Great North Road Solar and Biodiversity Park

Draft Statement of Common Ground with Nottinghamshire County Council

Document reference – EN010162/APP/8.1A

Site Access Locations
Figure 14.4 NE
Great North Road Solar and
Biodiversity Park
Environmental Statement

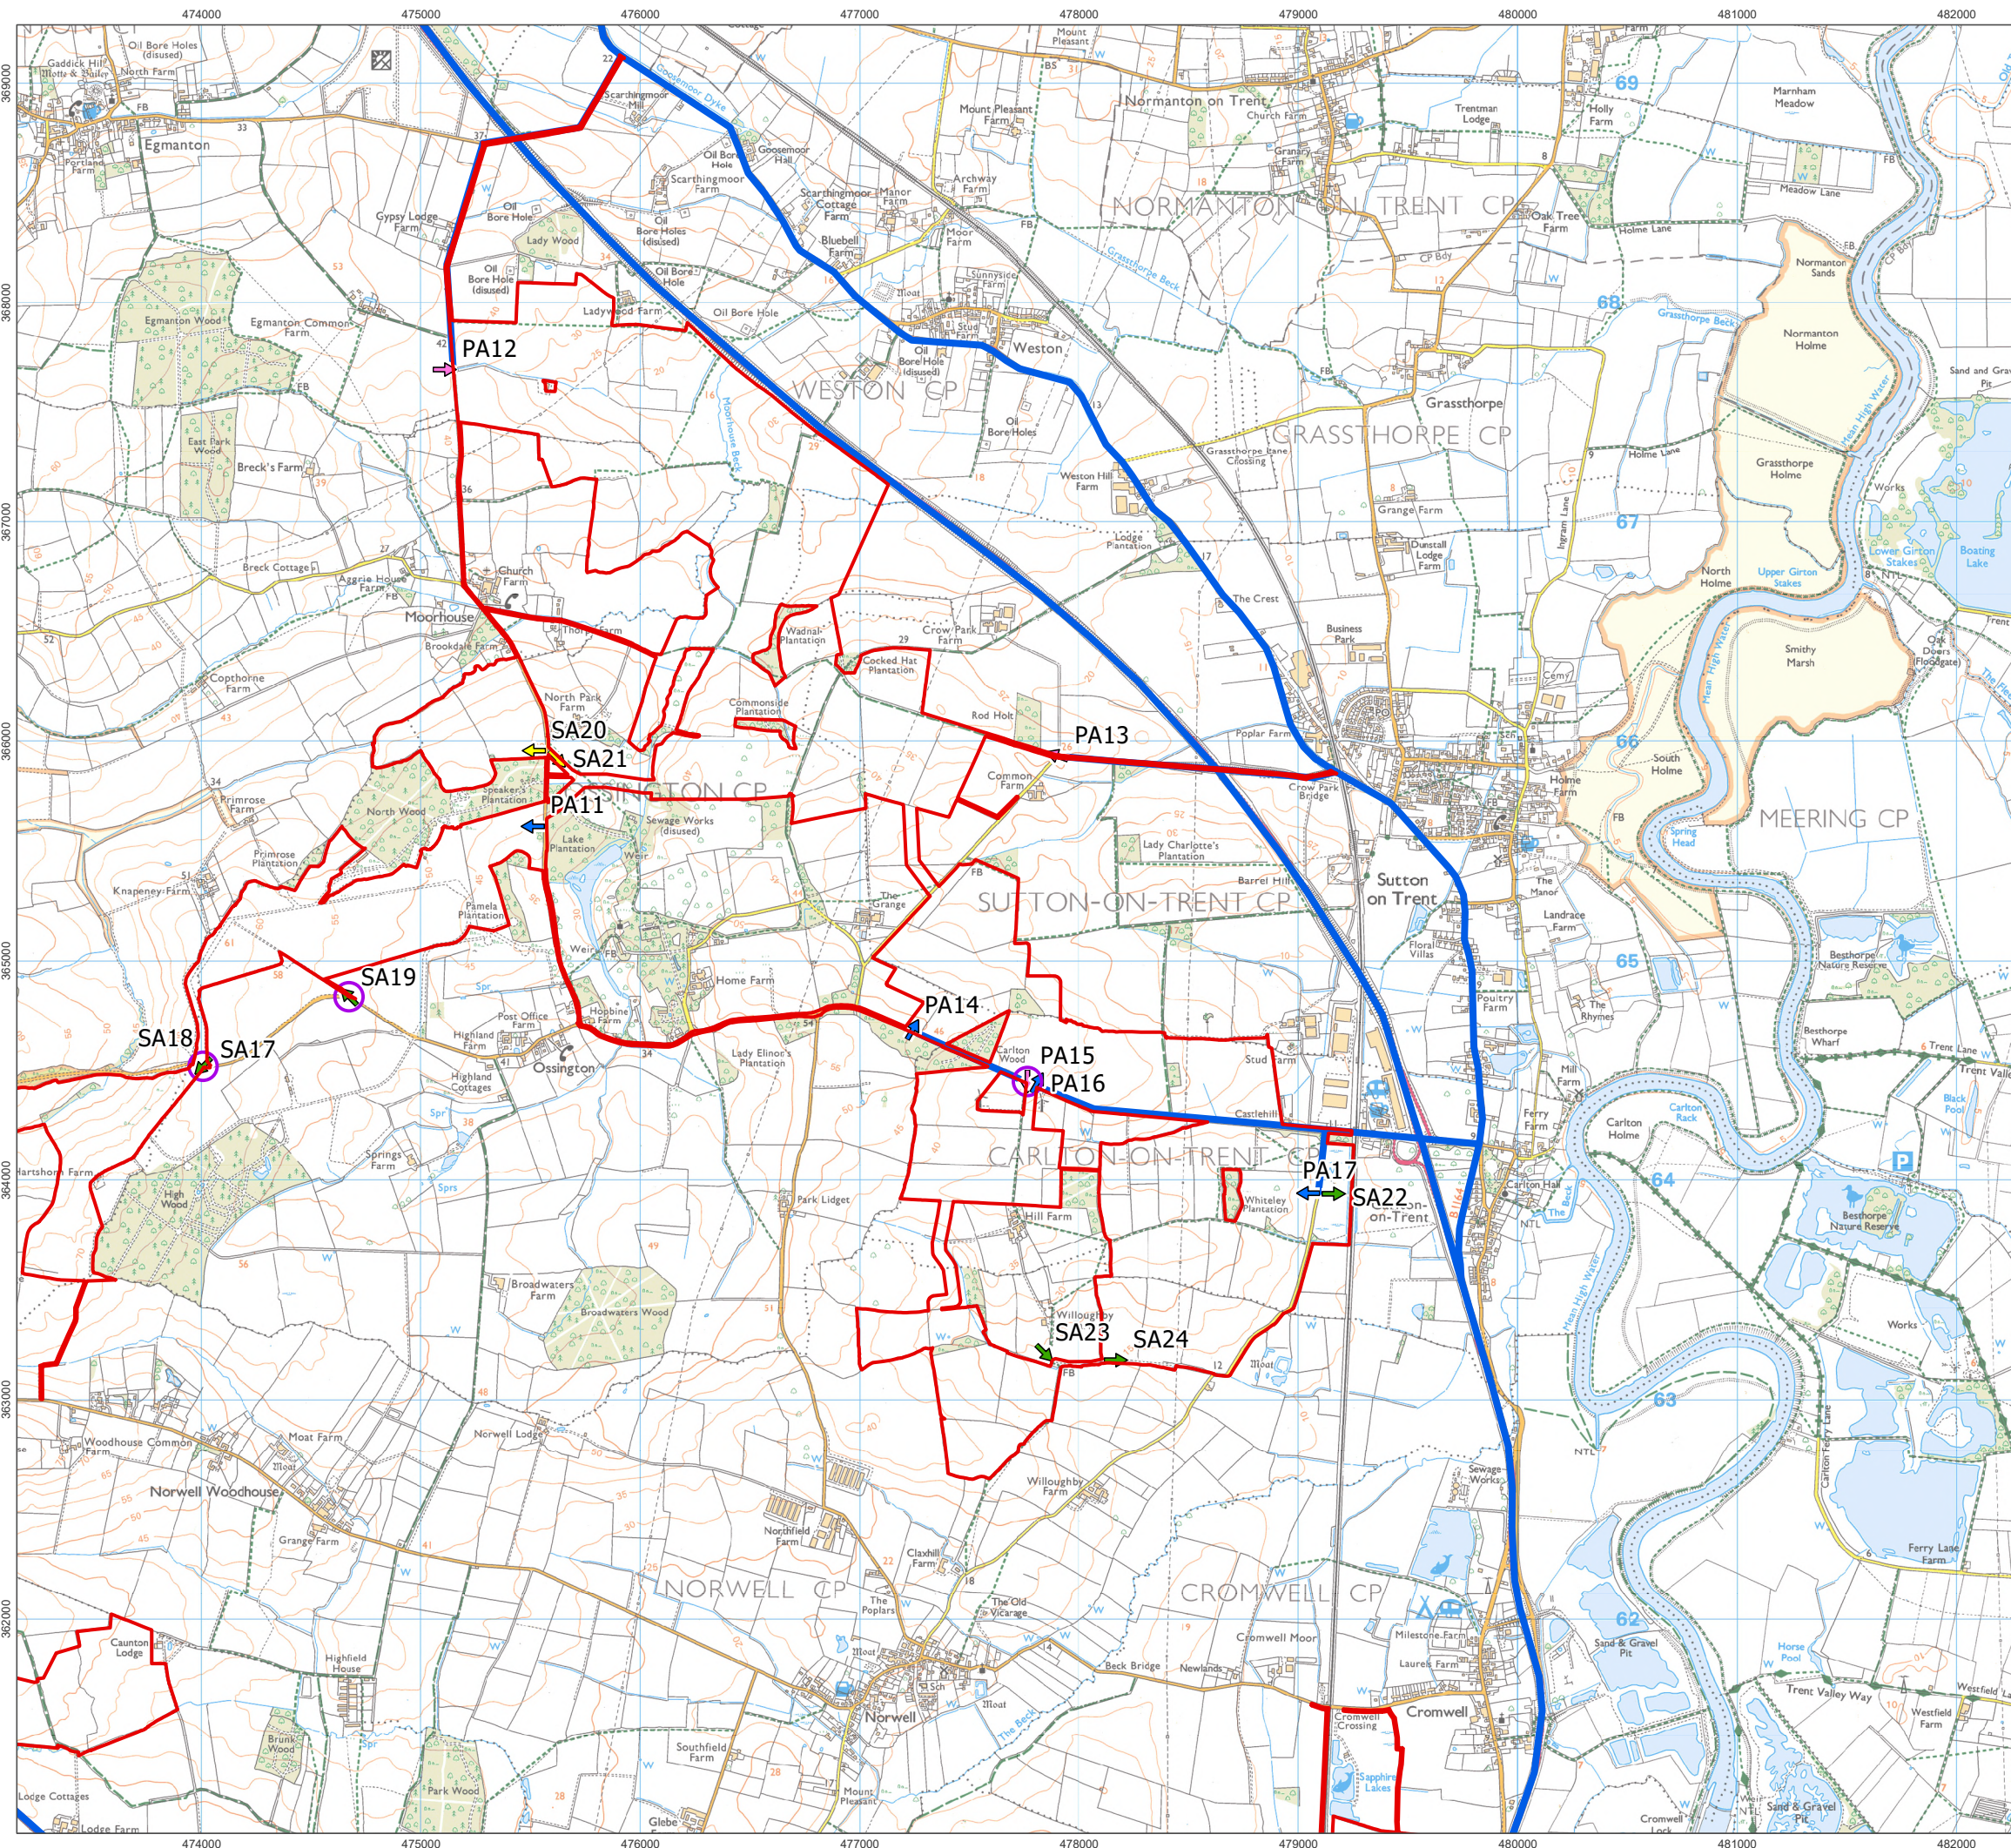
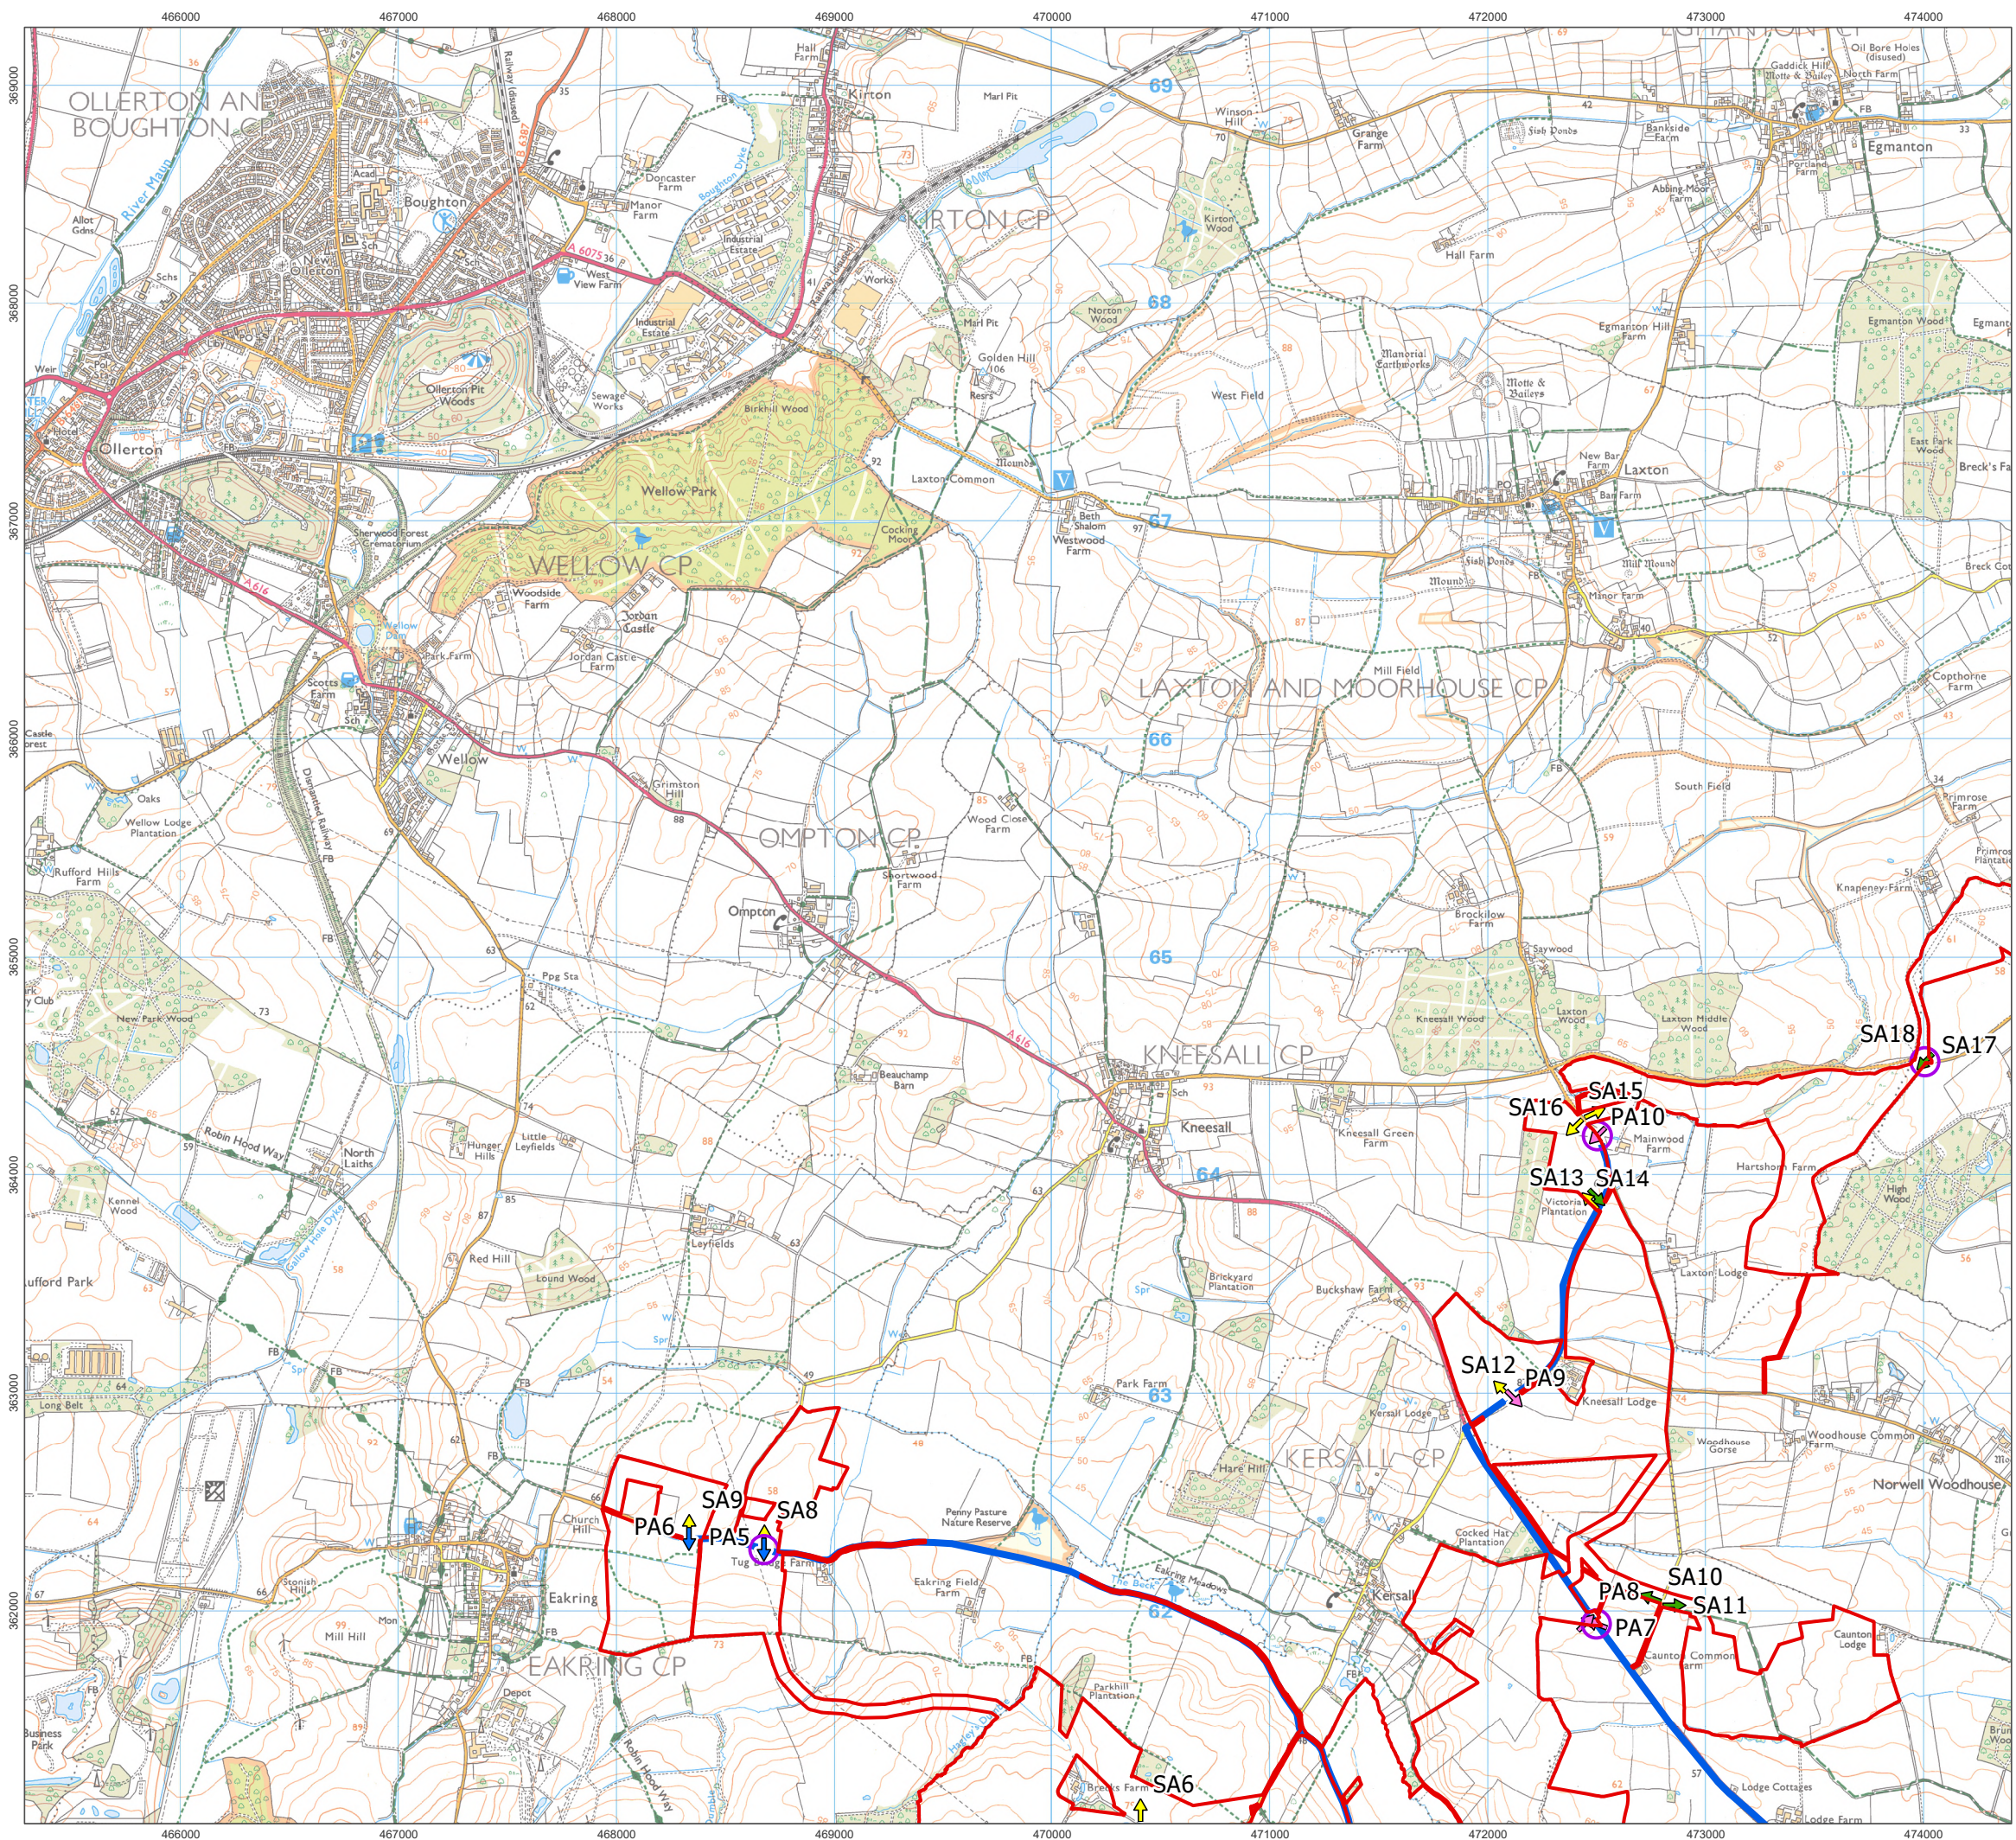
Ref	Document Reference	Description of Matter	Applicant's Position	NCC's Position	Status
				to apply such optimistic discounts.	
2.5.8	RR	Accesses	The Access Routes Hierarchy is shown in ES Volume 3, Figure 5.1: Works Areas [EN010162/APP/ 6.3.5B]. The Site Access locations are then shown at ES Volume 3, Figure 14.4: Site Access Locations [EN010162/APP/6.3.14A] and ES Volume 3, Figure 14.5: Passing Place Locations [EN010162/APP/6.3.14A]. ES Volume 4, Appendix A14.1: Transport Statement [EN010162/APP/6.4.14.1A] Appendix D provides the site access designs, including their form, key dimensions and demonstrates their suitability through swept path analysis of the largest anticipated HGV entering and exiting each respective location. This analysis of the construction access points confirms that they can be designed to meet relevant design standards. The Applicant will engage with NCC (the Local Highway Authority) to provide any further information, including the timing of Road Safety Audits.	No consideration to the form of access appears to have been given. The traffic information supplied identifies that a number of the accesses trigger the requirement in DMRB CD123 for further assessment, during both the construction and operational phase. Where only occurring in the construction phase, mitigation in the form of traffic management may be acceptable, but locations where this would be required should be identified. Information regarding the number of HGVs at each access was requested, and whilst information in Appendix F provides a breakdown, it is difficult to link the	Under Discussion

Ref	Document Reference	Description of Matter	Applicant's Position	NCC's Position	Status
				accesses in here to those described elsewhere and therefore clarity is required. Whilst a statement is made that the access drawings are outline drawings and detailed designs will be forthcoming at the appropriate time, the principle of acceptability needs to be established. There are a number of accesses, either proposed or amended (with increased usage) which have apparent highway safety concerns. All new or amended accesses should therefore be subject to a Stage 1 Road Safety Audit, as required by the Nottinghamshire Highway Design Guide, to inform this process.
